WEST SUSSEX COUNTY COUNCIL CONSULTATION

TO:	Arun District Council FAO: Anita Gardner
FROM:	WSCC - Highways Authority
DATE:	2 April 2019
LOCATION:	Church Farm Cottage, 76-78 The Street, Littlehampton, BN16 3NR
SUBJECT:	R/61/19/PL Change of use from museum & cafe to single dwelling. This application may affect the character & appearance of the Rustington Conservation Area.
DATE OF SITE VISIT:	N/A
RECOMMENDATION:	Advice
S106 CONTRIBUTION TOTAL:	N/A

Drawing: Conversion to single dwelling – block/site layout plan

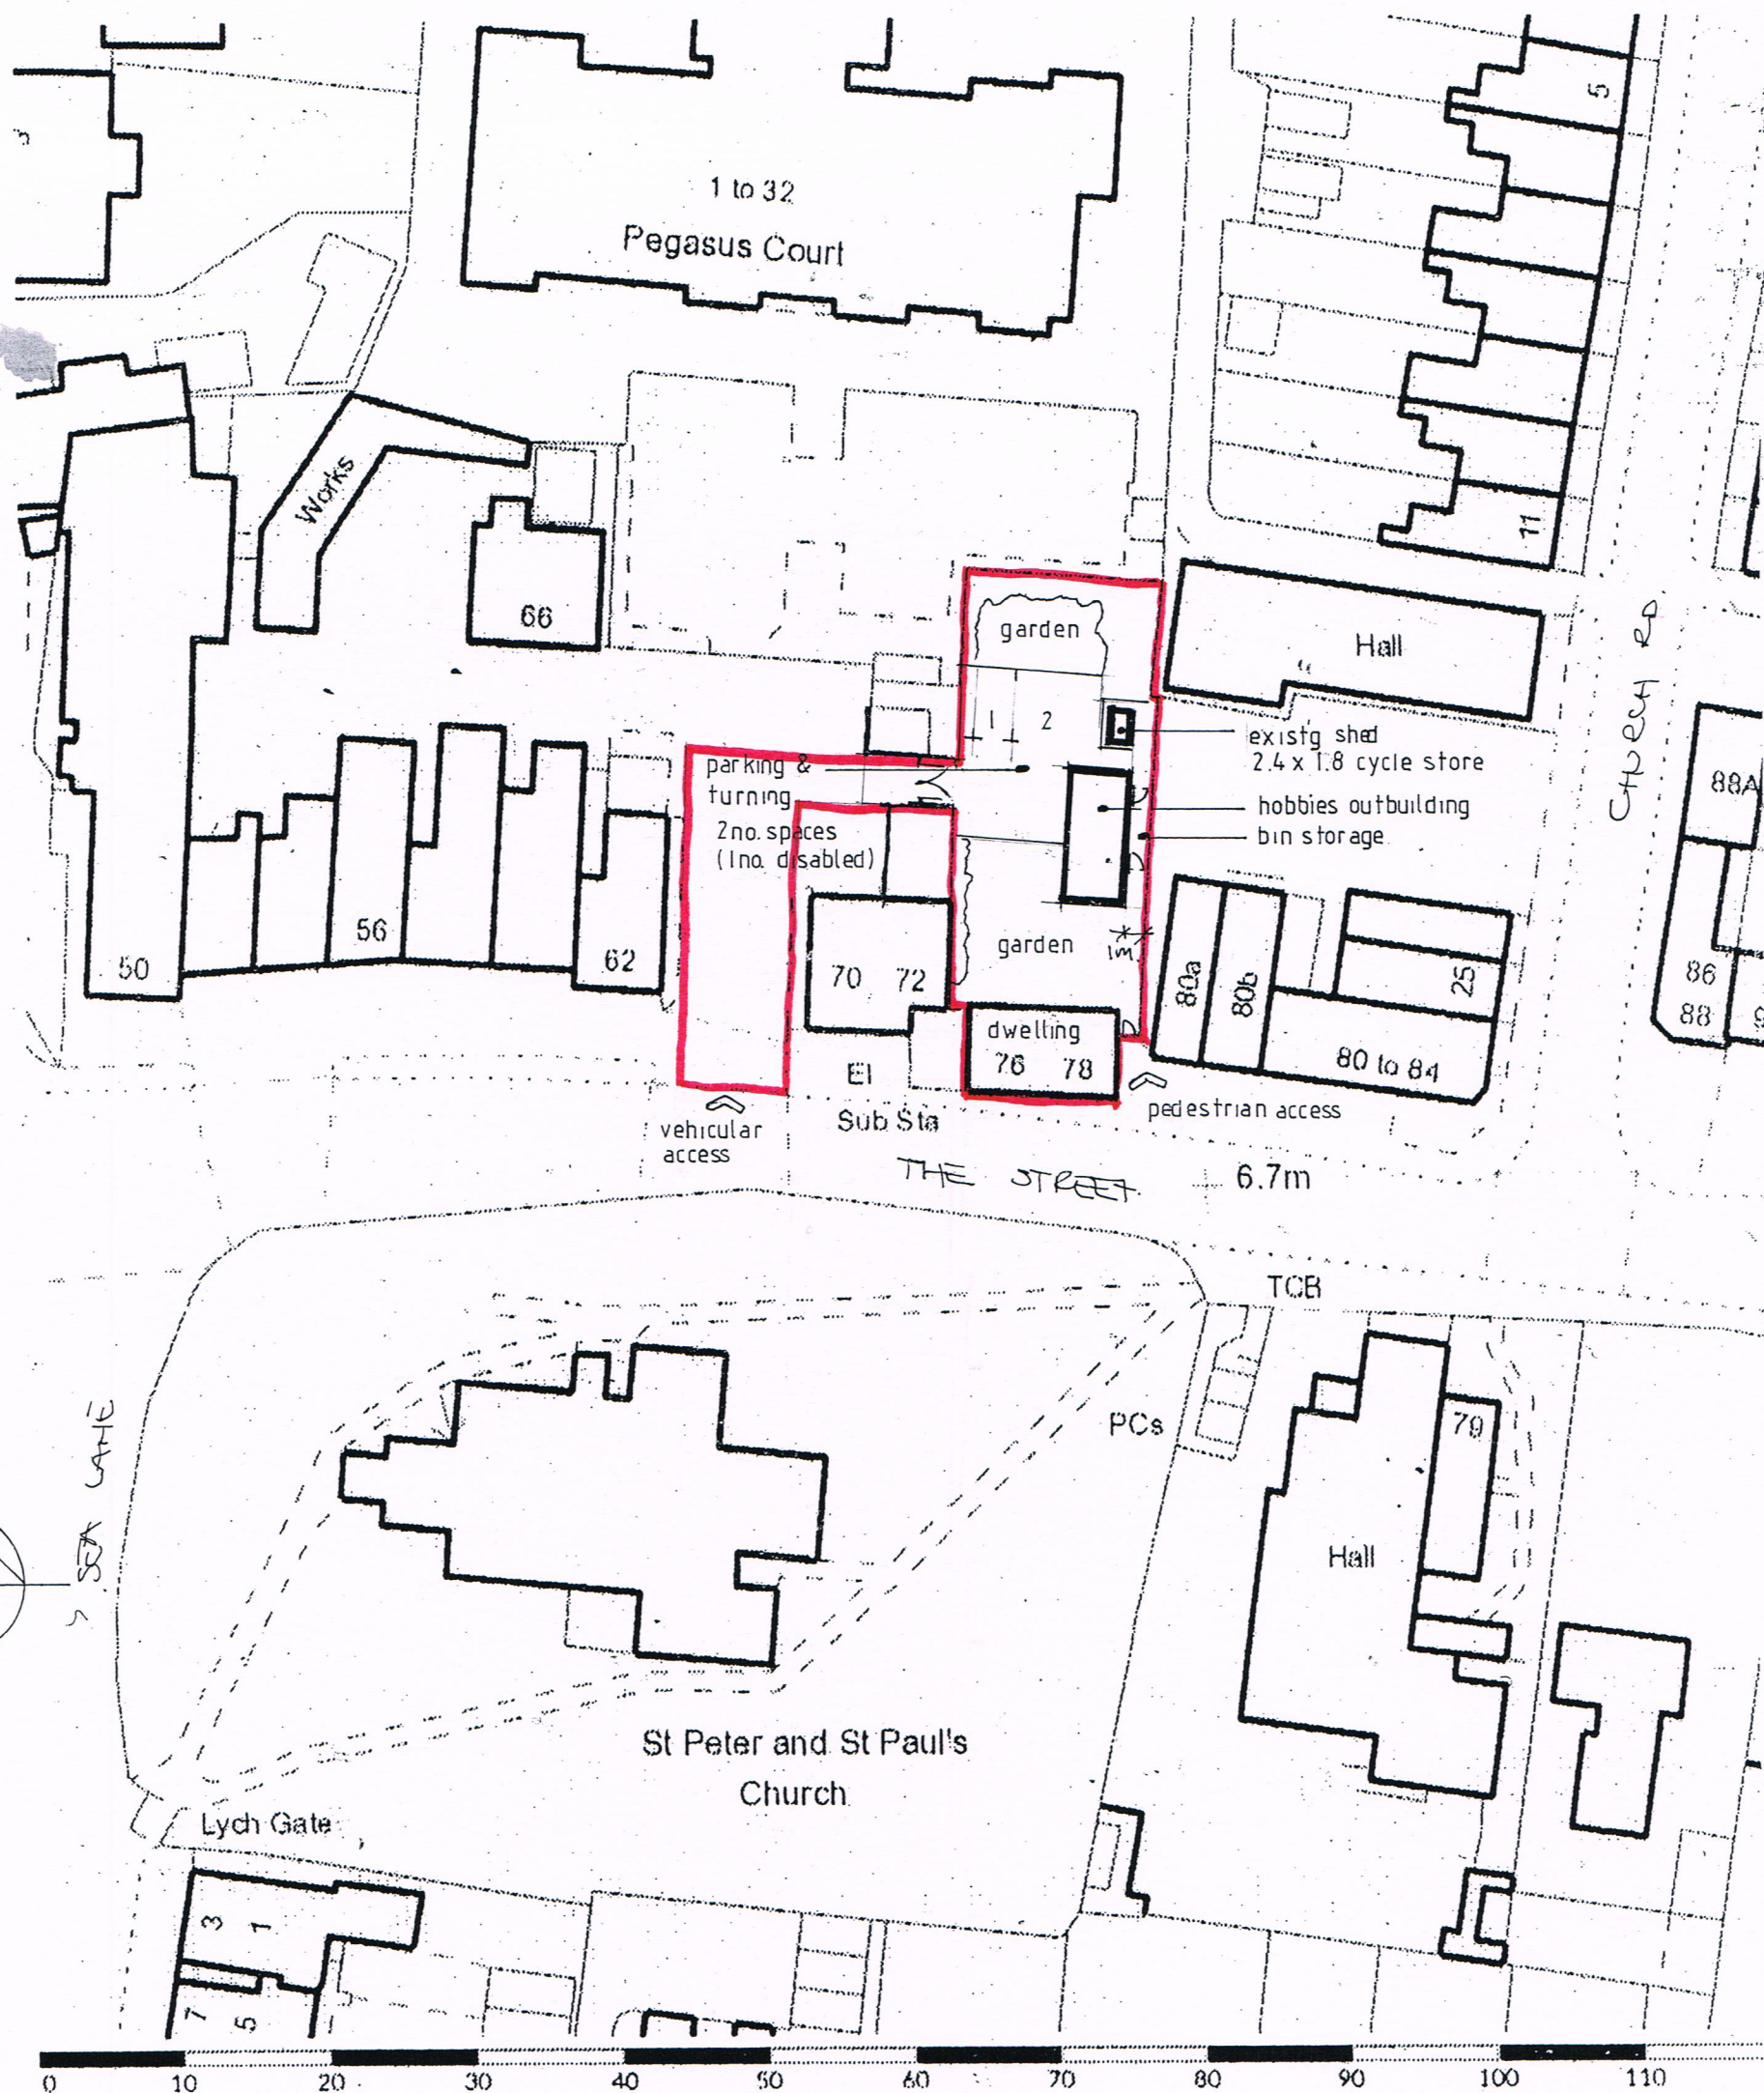
The site currently benefits from access onto The Street via a private access road to the west of the site, shared with the Pegasus Court development and parking areas for other retail uses along The Street. No alterations to the existing access onto The Street are proposed. The applicant proposes to provide a gated entrance to the site. This opens inwards of the site and is sited within the private access and vehicles will not obstruct the public highway whilst the gates are being operated.

The proposed plans indicate that two parking spaces will be provided onsite, including one disabled parking space. These spaces meet minimum specifications as set out in Manual for Streets (MfS) and the WSCC Parking Demand Calculator anticipates that this is a sufficient parking provision for a dwelling of this size and location. There appears to be sufficient space on site for vehicles to turn on site and exit onto the public highway in a forward gear.

No part of the development shall be first occupied until the vehicle parking and turning spaces have been constructed in accordance with the approved plan. These spaces shall thereafter be retained for their designated use.

No part of the development shall be first occupied until covered and secure cycle parking spaces have been provided in accordance with the approved plan.
